Wednesday ISH2 12/03/25

Lesley Marson speaking as a resident, on behalf of family group, and as a HALT representative

APP-027 6.1 Environmental Statement Chapter 7 – Landscape and Views

## **Environmental Statement Figure 15.1: Cumulative Schemes Plan**

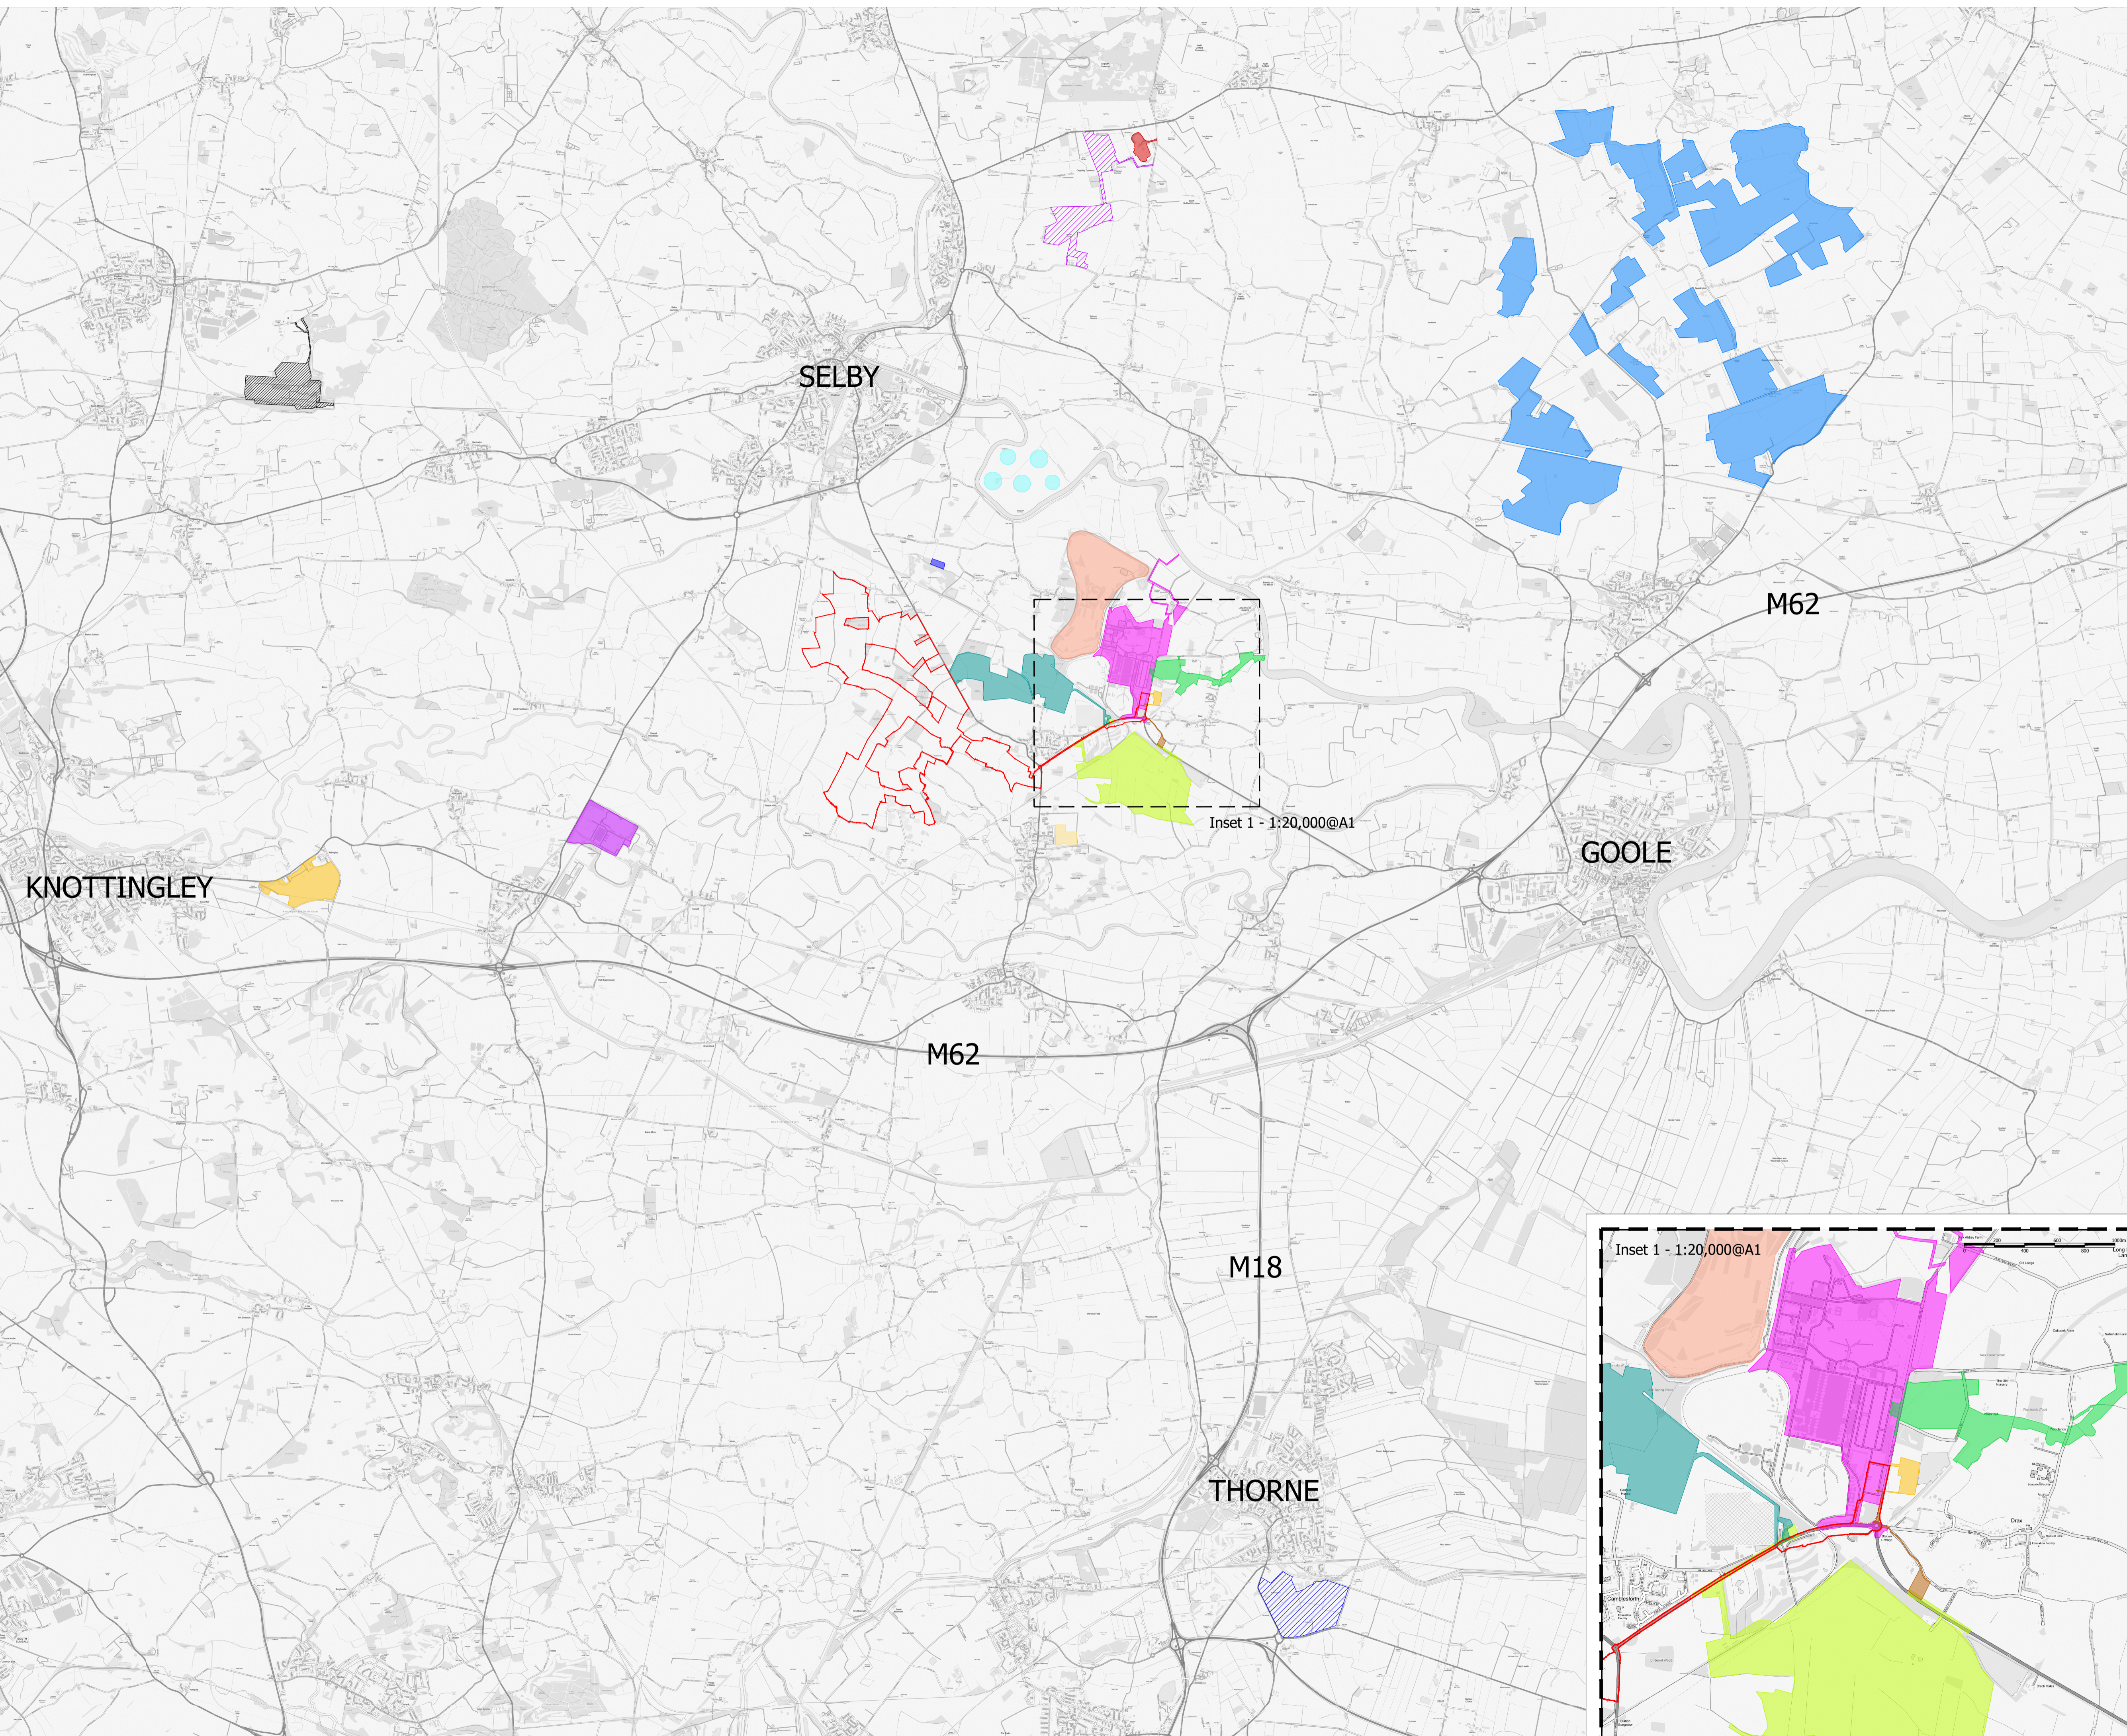
Q13. With this in mind why has the applicant scoped out the majority of projects known to be proposed or accepted in the area, even though the impacts on the local area and residents is likely to be immense, choosing only to scope in the 2 Lanpro solar farms?

The applicant only considers the 2 Lanpro Solar farms alongside this project within scope for cumulative effect, if only considering these 3 solar farms we are still looking at a substantial cumulative impact and loss of BMV land, and this is without considering other proposed developments in the area:

When it was raised that several other local projects had been scoped out and that the applicant had only chosen to scope in 2 projects, the applicant responded suggested that the date for other projects in the area to be considered as part of their cumulative impact assessment had gone, and that it was now down to other projects to include the Helios project within their cumulative impact assessments instead. I responded by saying: We are at the point of discussing cumulative effects within this process, so an arbitrary date, regarding submissions of other projects, seems less important than that of taking on a holistic view and the reality we are faced with. We live close to a grid connection point and a race by projects to connect to this. We could be facing any number of projects, we really don't know how many this will end up being. So, I do think we have to consider all projects that we have knowledge of, at this point in time, to gain a true picture of the cumulative effect..

Environmental Statement Figure 7.3: Landscape Character Plan

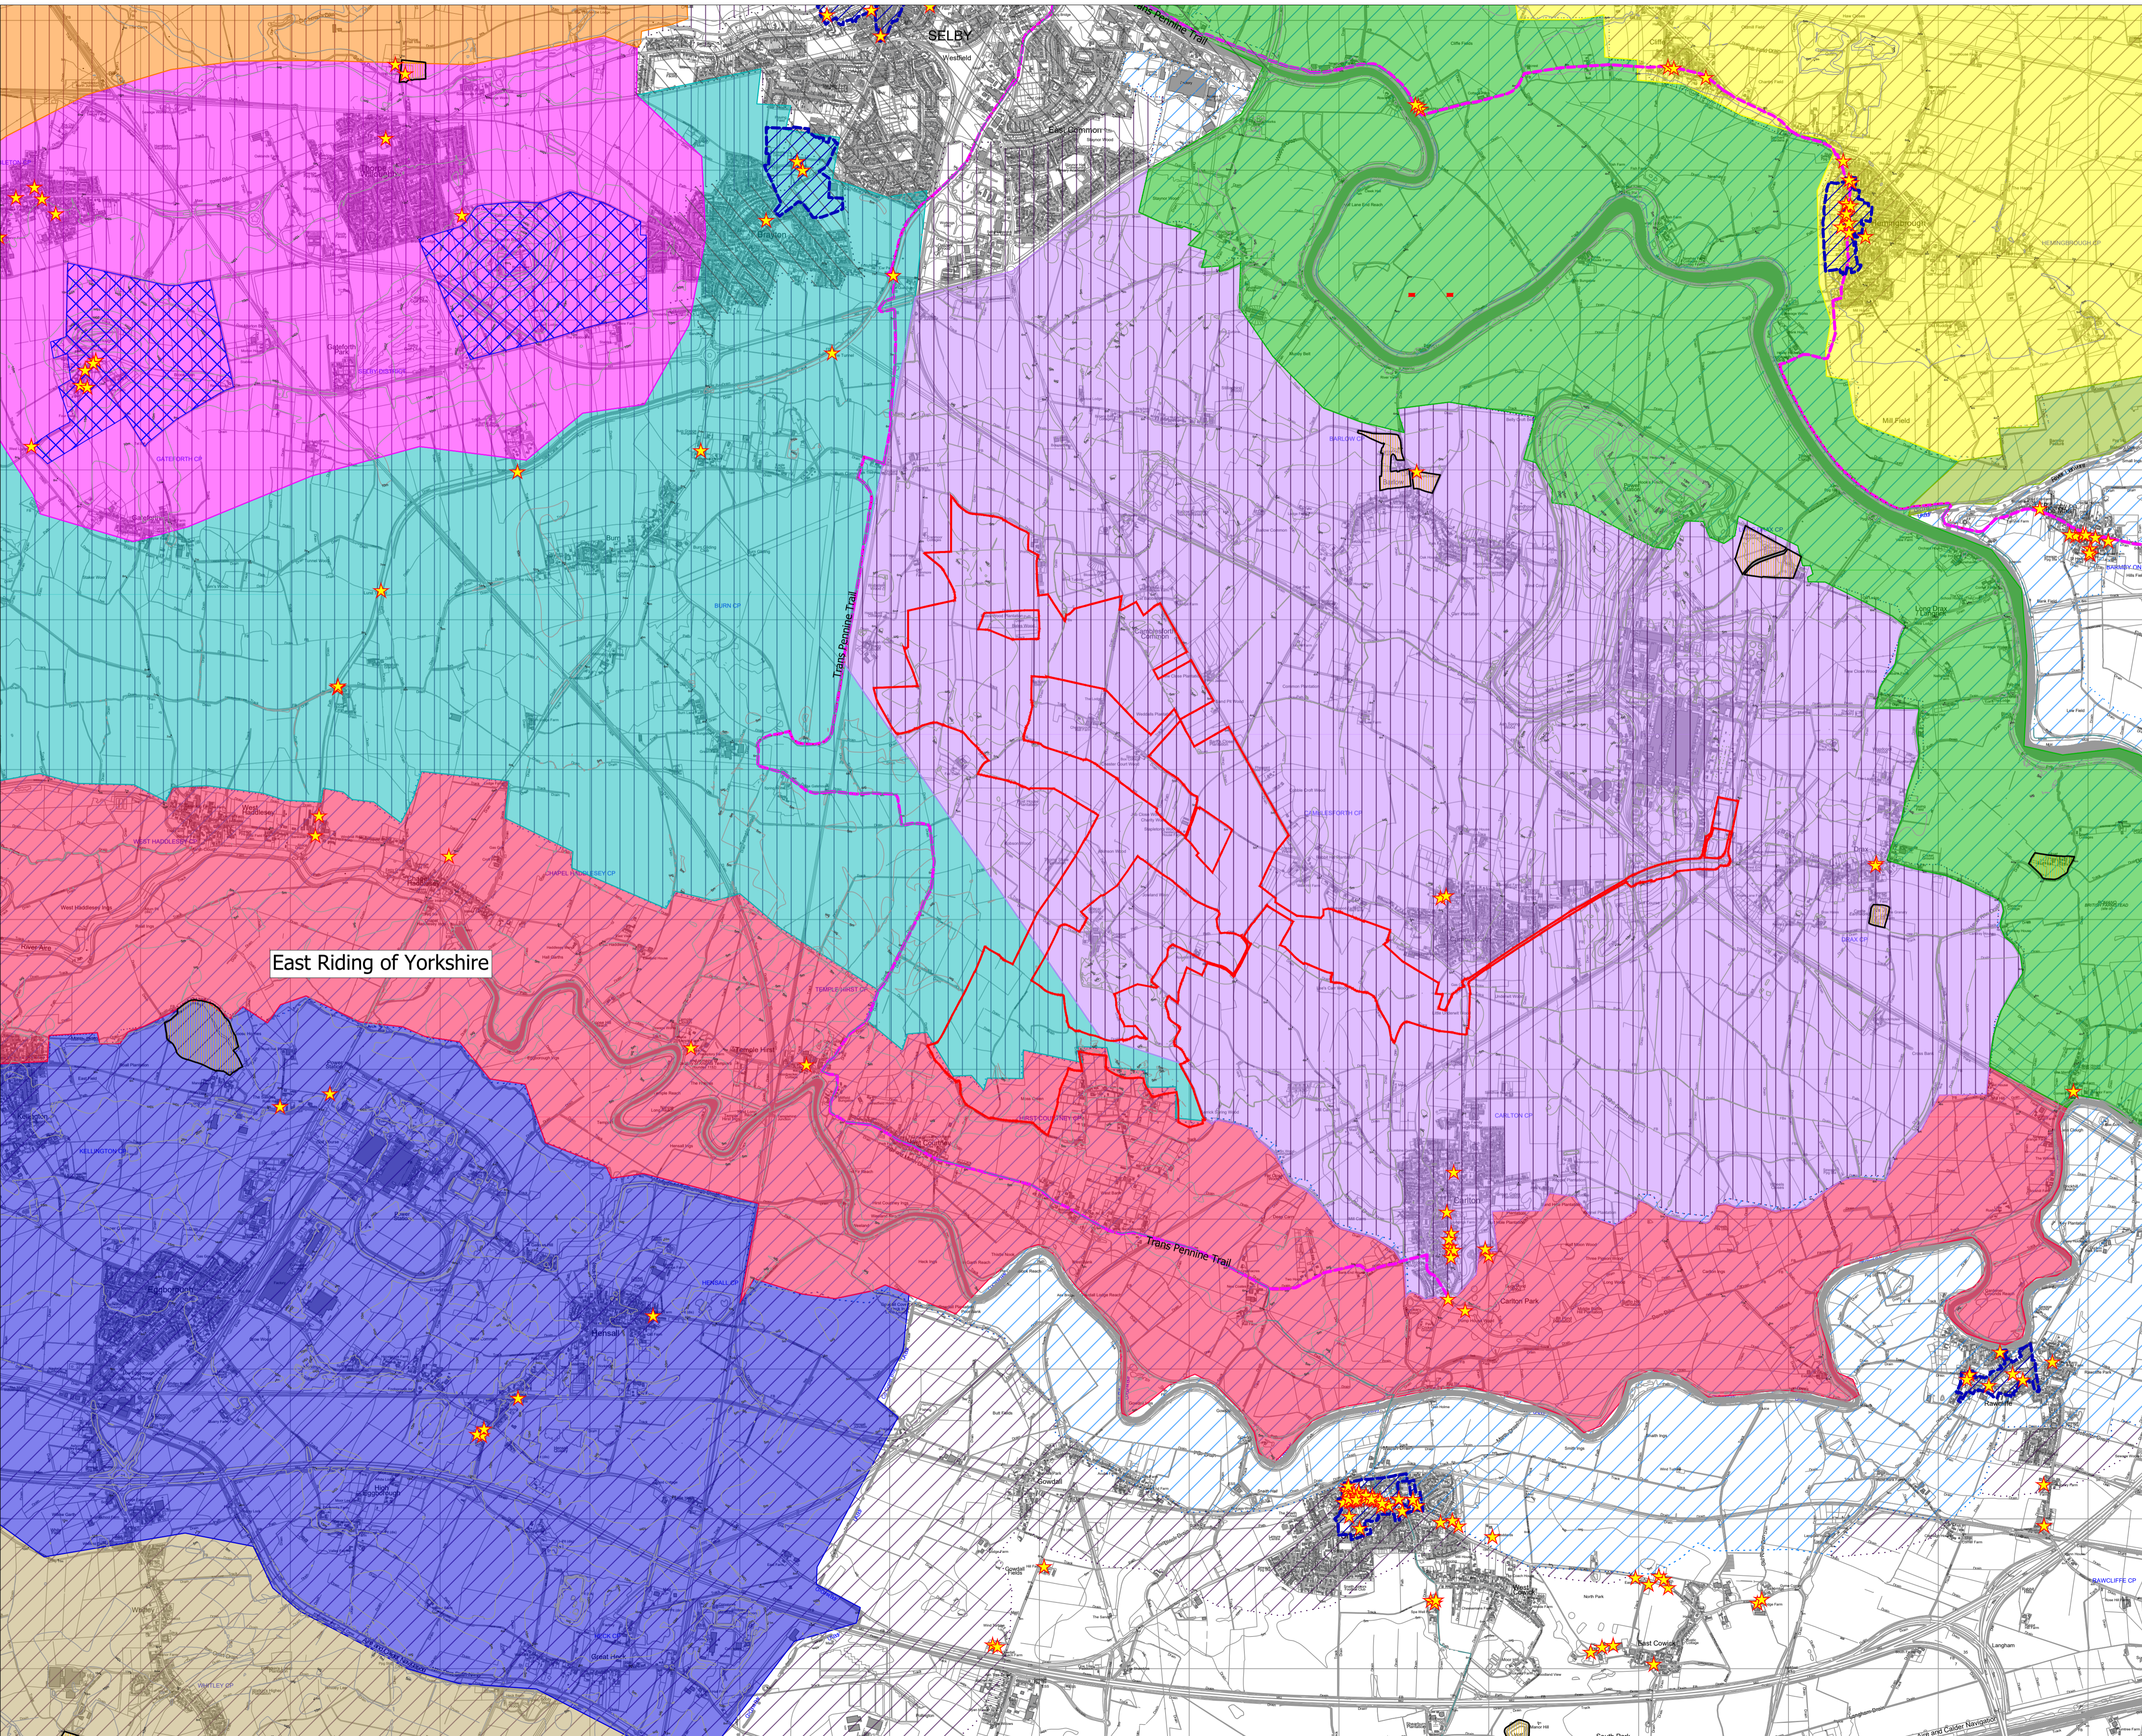
7.5.36. In relation to landscape character, the majority of the Site lies within the Camblesforth Farmlands LCA

7.5.49. States that a comparable major/moderate and significant effect would occur in relation to the Camblesforth Farmland, the LCA in which the majority of the Proposed Development will be located. The Proposed Development would occupy a large proportion of this LCA and would result in a large level of landscape change.
